RE: **Broadstone Highlands Mid Block- Parking Lot & Ped. Bridge
Central and Cedar NE
Grading and Drainage Plan
Engineer's Stamp Date: 12/6/19 & 10/11/19
Hydrology File: K15D034D**

Based on the submittal received on 12/6/19 the above-referenced Grading and Drainage Plan cannot be approved until the following are corrected:

C-001
SHEET NUMBER

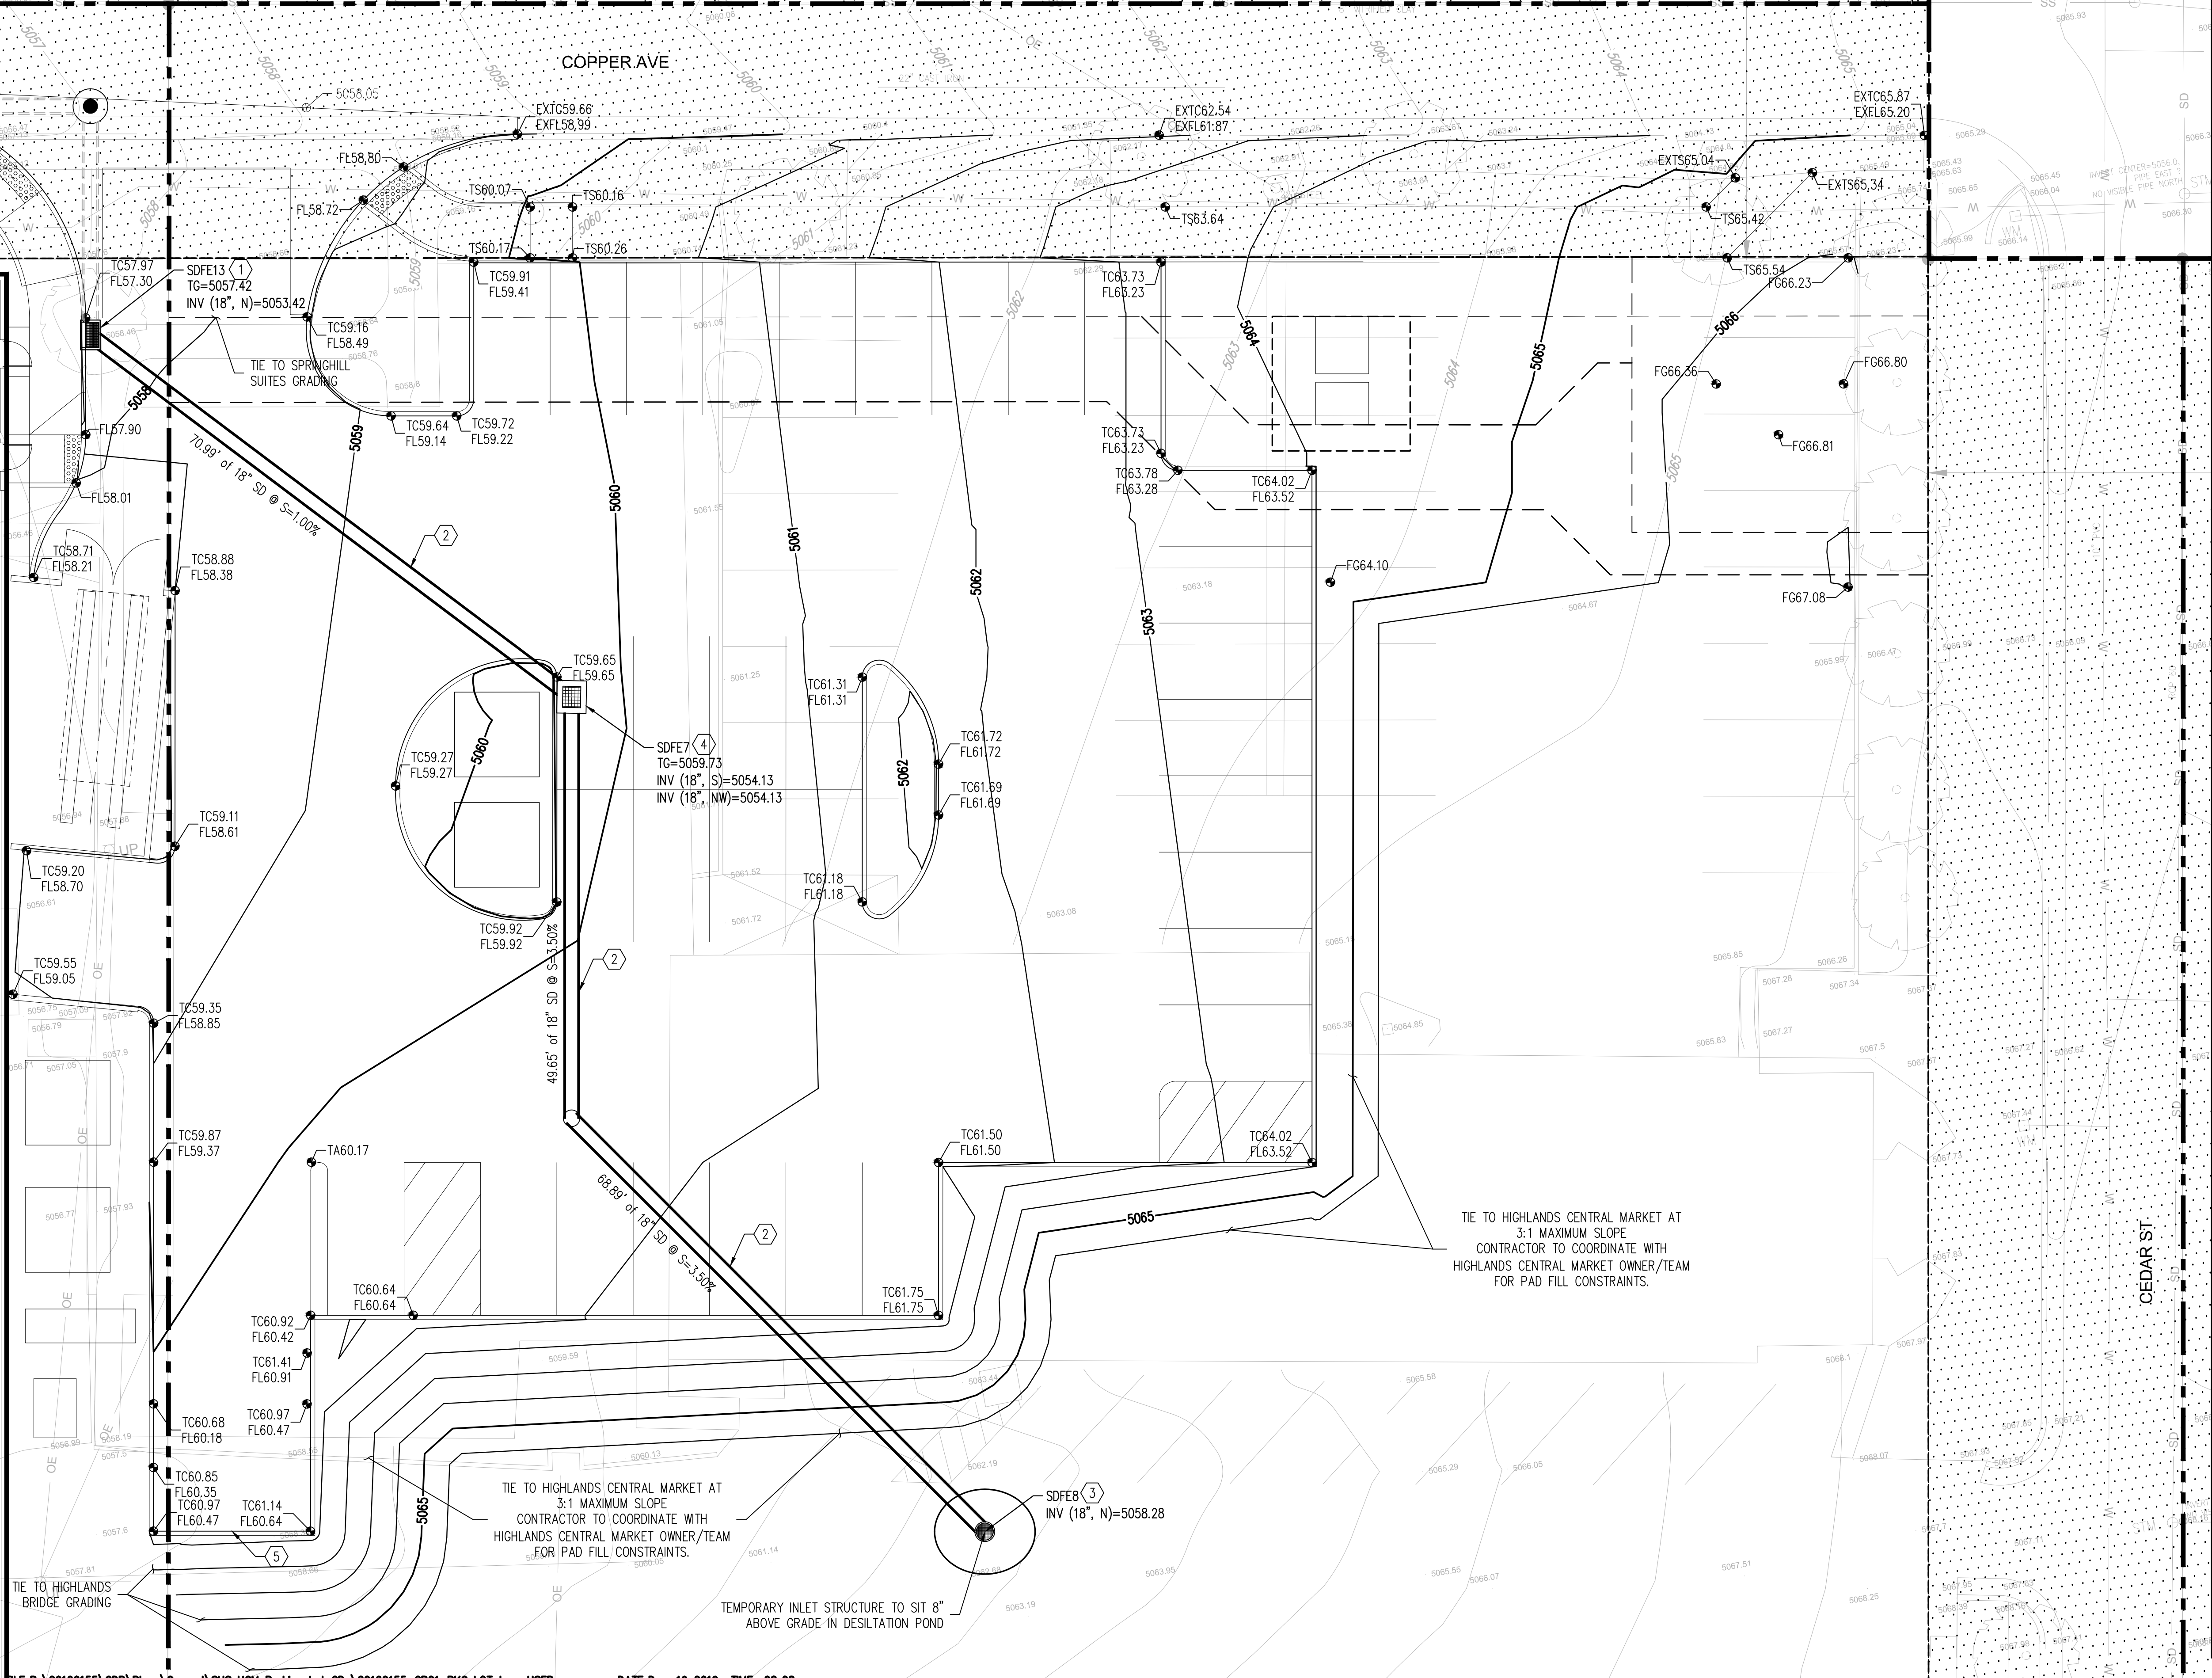
2. Payment in Lieu (Amount = $1983\text{CF} \times \$8/\text{CF} = \15864 , per sheet C-001) of onsite management of the SWQV must be made. Take three copies of the treasury deposit slip to the Treasury and then include one copy of the paid deposit slip when resubmitting.
